From: Masha White <[REDACTED]>
Sent: 29 January 2026 13:00
To: Freya Clewley <Freya.Clewley@arun.gov.uk>
Subject: Objection to FP/167/25/HH

Application No. FP/167/25/HH 7 Lindsey Court, Felpham

Proposed Annex
Plans and Elevations
Planning
Date
March 2022
Scale
1:50

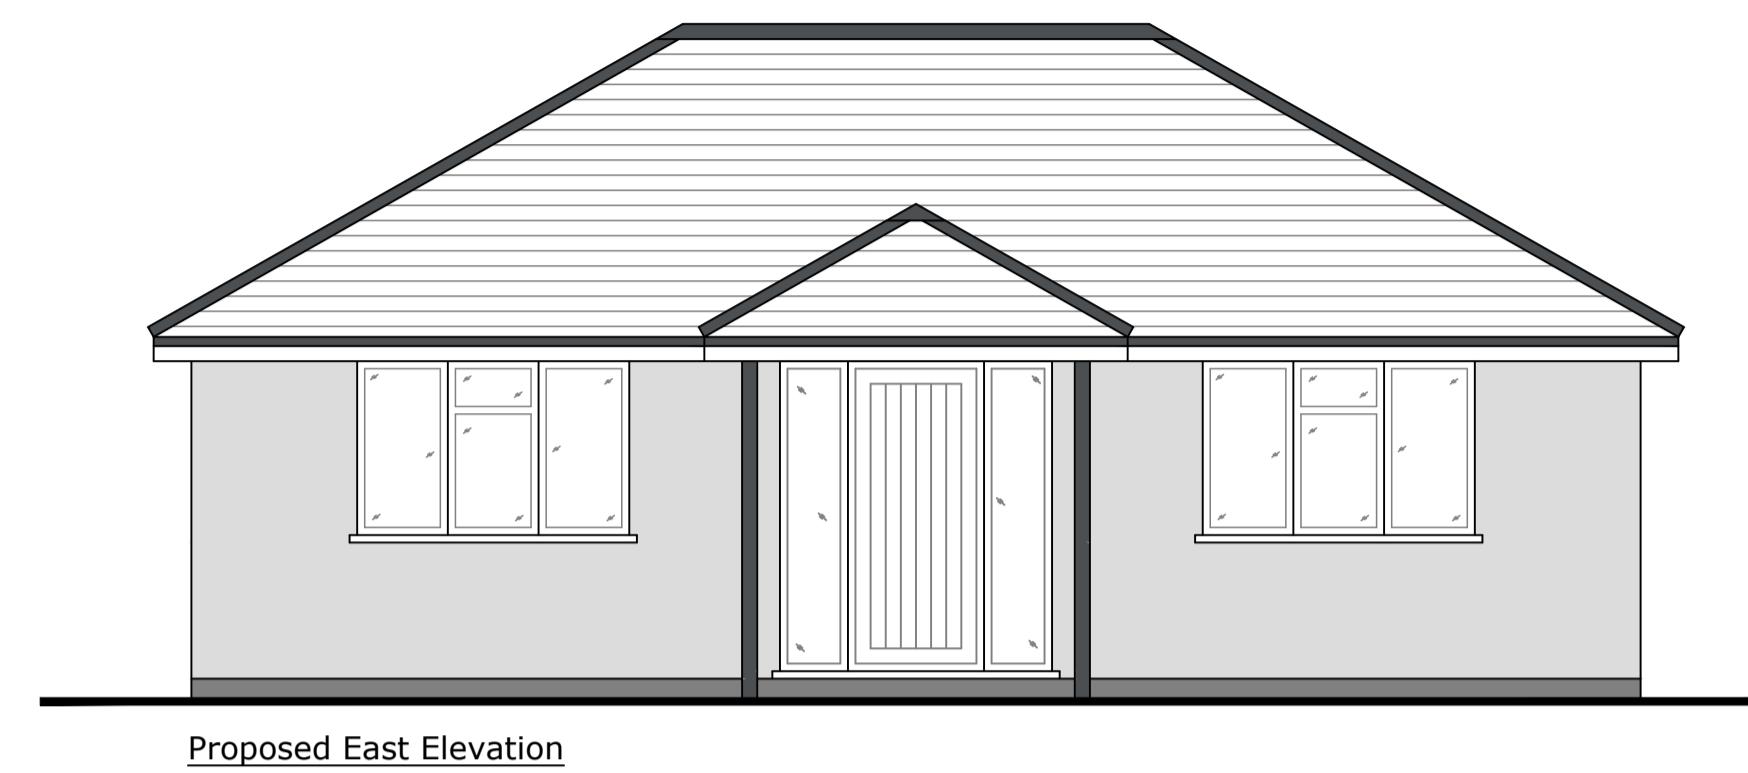
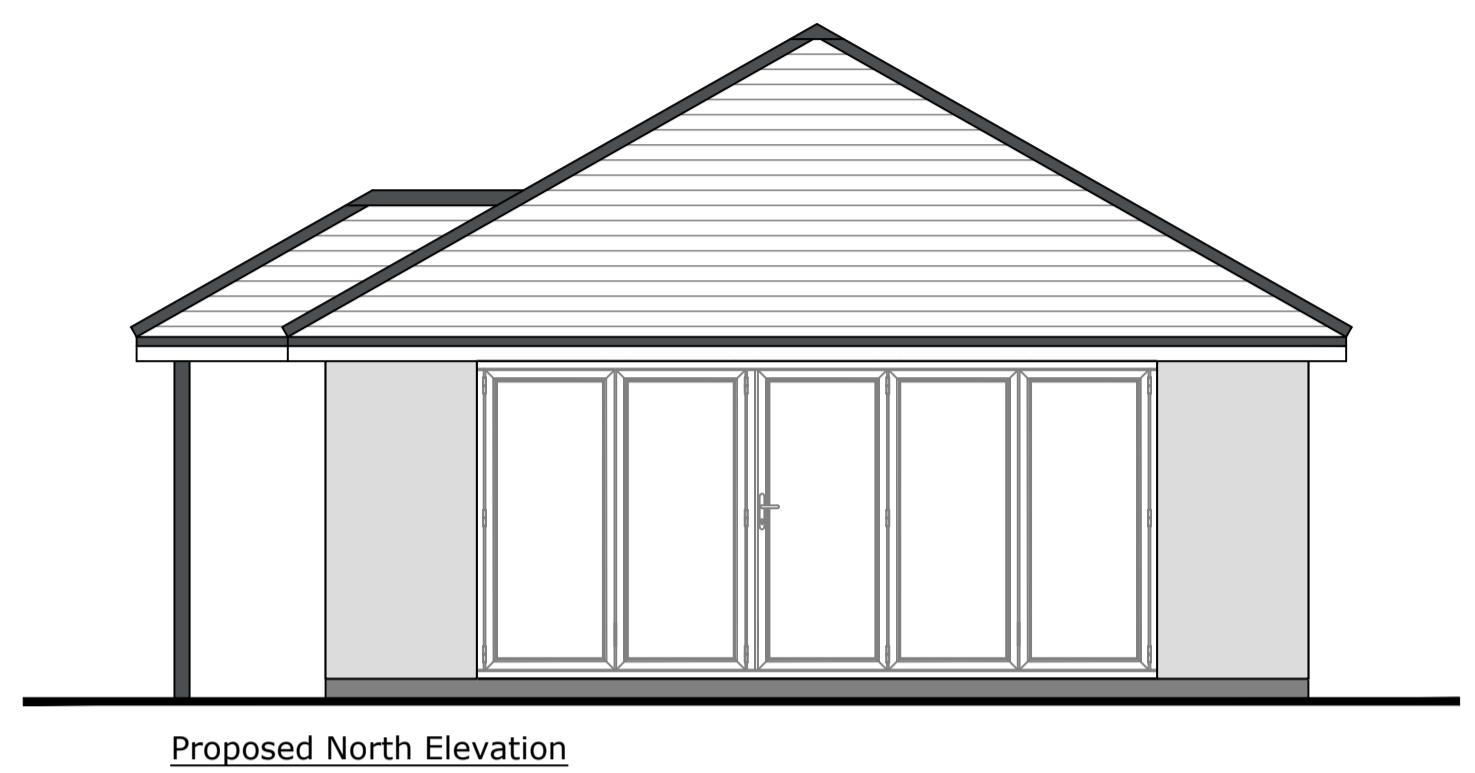
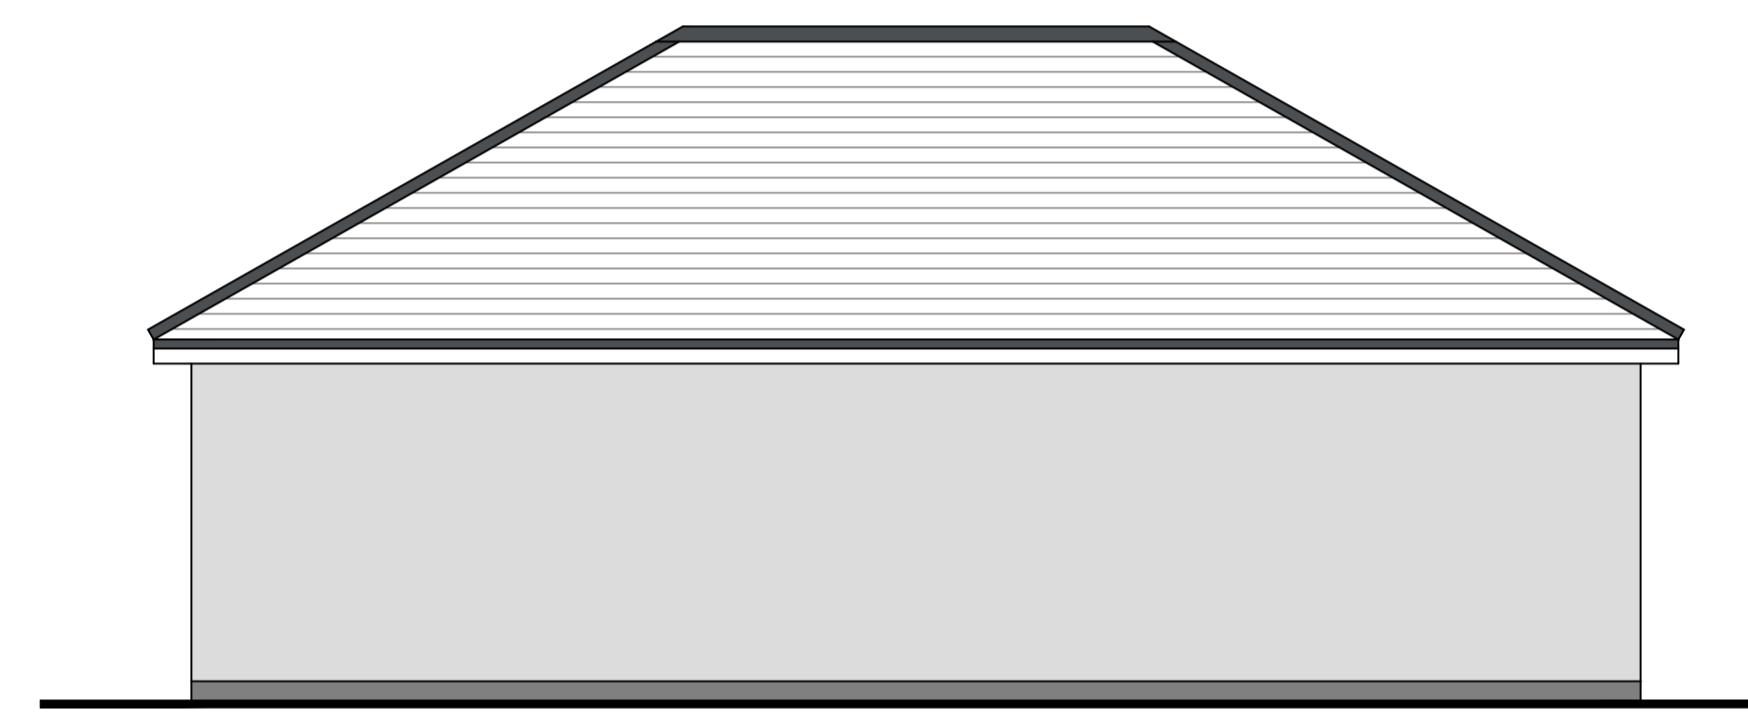
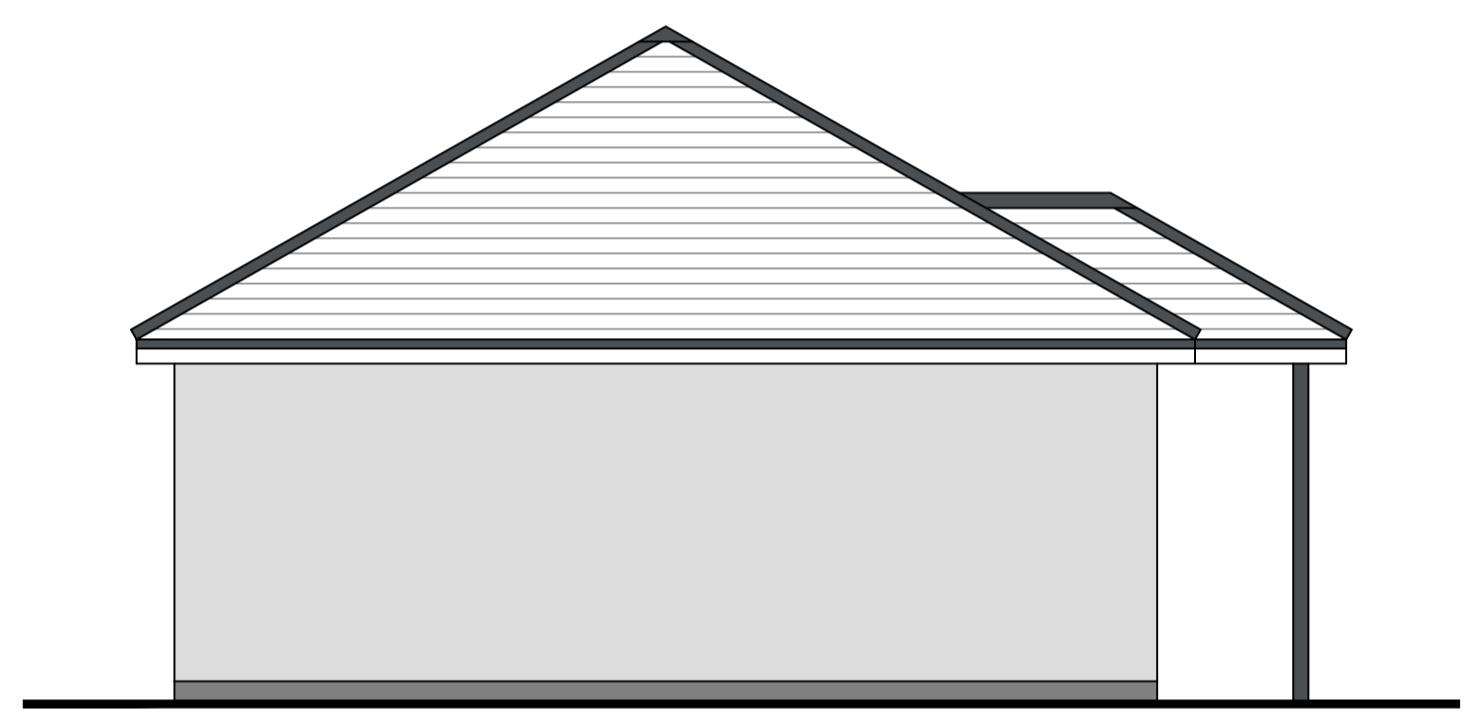
2. We are particularly concerned that the proposed building would be right on our boundary. There is no provision for access to the rear or side of the property for regular maintenance. Under the terms of the 1990 Town and Country planning Act, for buildings up to 2.5 meters in height a space of 0.3 to 1.0 meters is usually considered practical and if the building is within 2 meters of a boundary its maximum height must not exceed 2.5 meters. If the building is taller, up to 4 meters it must be positioned at least 2 meters from the boundary. The plan submitted does not specify dimensions, but given the fact that it would have a pitched roof we believe it would be more than 4 meters high.

4. Siting the new build against our boundary means that given the pitched roof our garden would collect fall out from the trees in the form of the regular acorn and leaf dropping. We already have a huge amount of such deposits and do not want more from next door. Every few years (Mast Years) Oak trees are subject to exceptional falls of acorns. Autumn 2025 was such a year. We had to collect and remove over 300 kilos of Acorns from our garden and the applicant had at least a similar amount, it therefore seems unreasonable that we should collect even more via the roof of the new build.

7. We were informed after the previous application that a special technique could be used to protect the tree roots to build on a type of raft with a crawl space under the building. Such a system if utilised would of course further increase the height of the building by 0.5 to 1.0 meters.

Proposed South Elevation

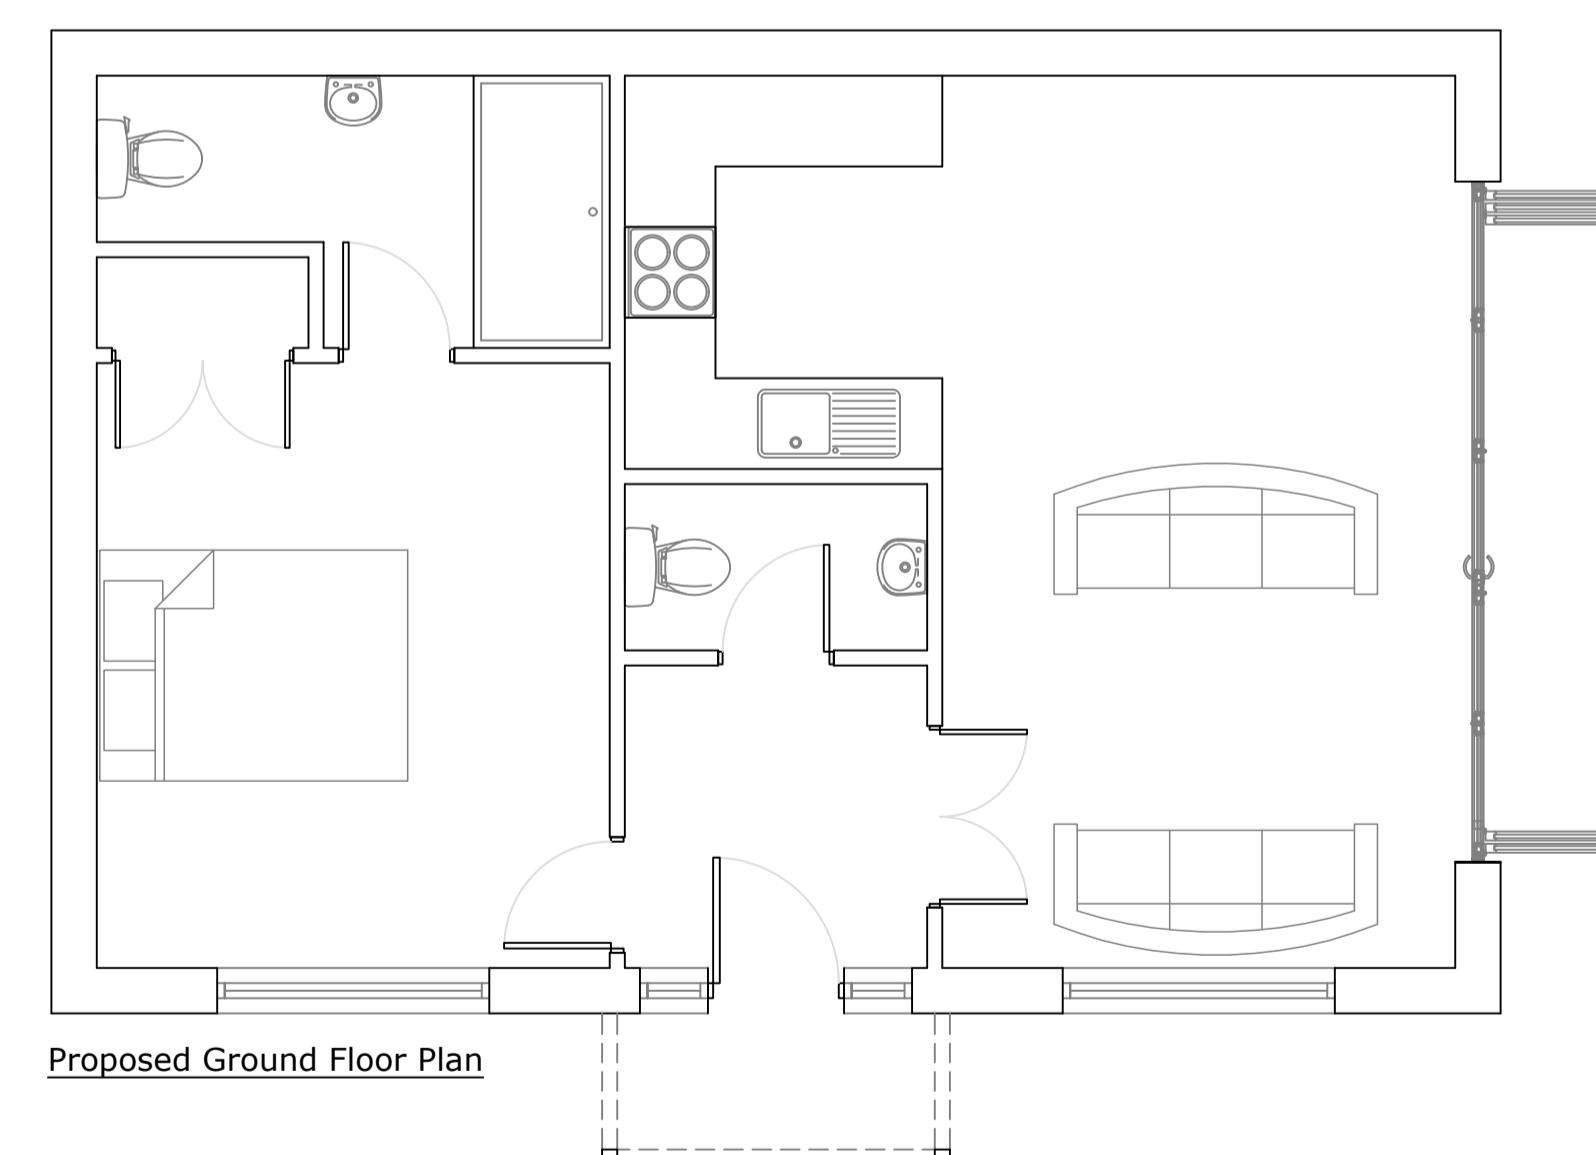
1. The proposed new build is an overdevelopment of a modest size plot, which has already been subject to several extensions. It is proposed as a self contained standalone annex as it would be outside permitted development if it were attached.

3. When "Site 6" was being developed to the rear of our garden we were told that no new building could take place within 25 meters of established TPO trees. The new build is well within 25 meters of our TPO tree and those in the applicant's garden. The canopy from these mature Oak trees would overhang the new build.
